SCOPING OPINION

Proposed Reinforcement to North Shropshire Electricity Distribution Network

Planning Inspectorate Reference: EN020021

April 2017

Diagram 3.2 – Illustration of different Trident pole types

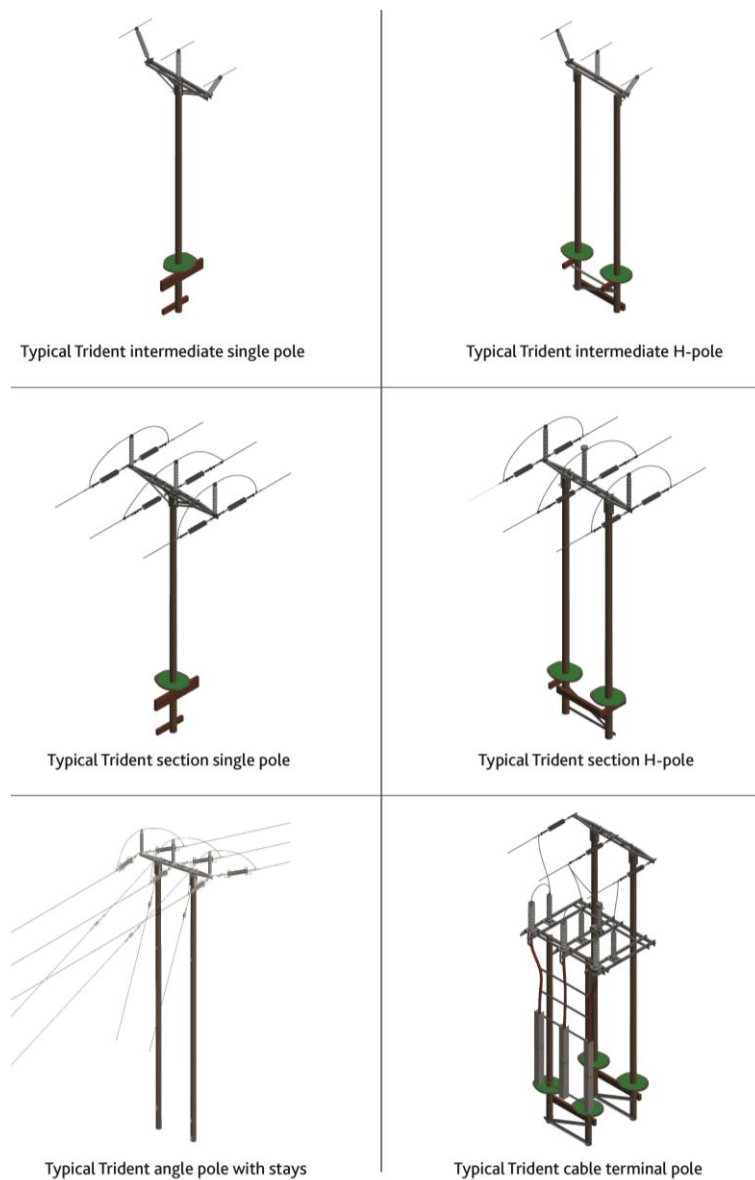
- 2.28 The SoS welcomes the inclusion of illustrations depicting Trident poles and alternative overhead line structures (paragraphs 2.1.9 and 3.4.16, respectively). It is noted that most references in the Scoping Report are to single poles; however, Section 3.4 indicates that 'H' structures may be used in a few locations (not illustrated). The SoS assumes the term refers to double Trident poles. All elements of the Proposed Development should be described in the ES, and the SoS would welcome the provision of illustrative diagrams. It is not stated whether the pole types in each location will be confirmed prior to the DCO application, or included in the application as an alternative option. The Applicant is referred in respect of this to the SoS's comments in the 'Flexibility' section below. The SoS also notes that the Applicant has not stipulated the number of poles that would be required, and assumes that this will be identified in the ES.
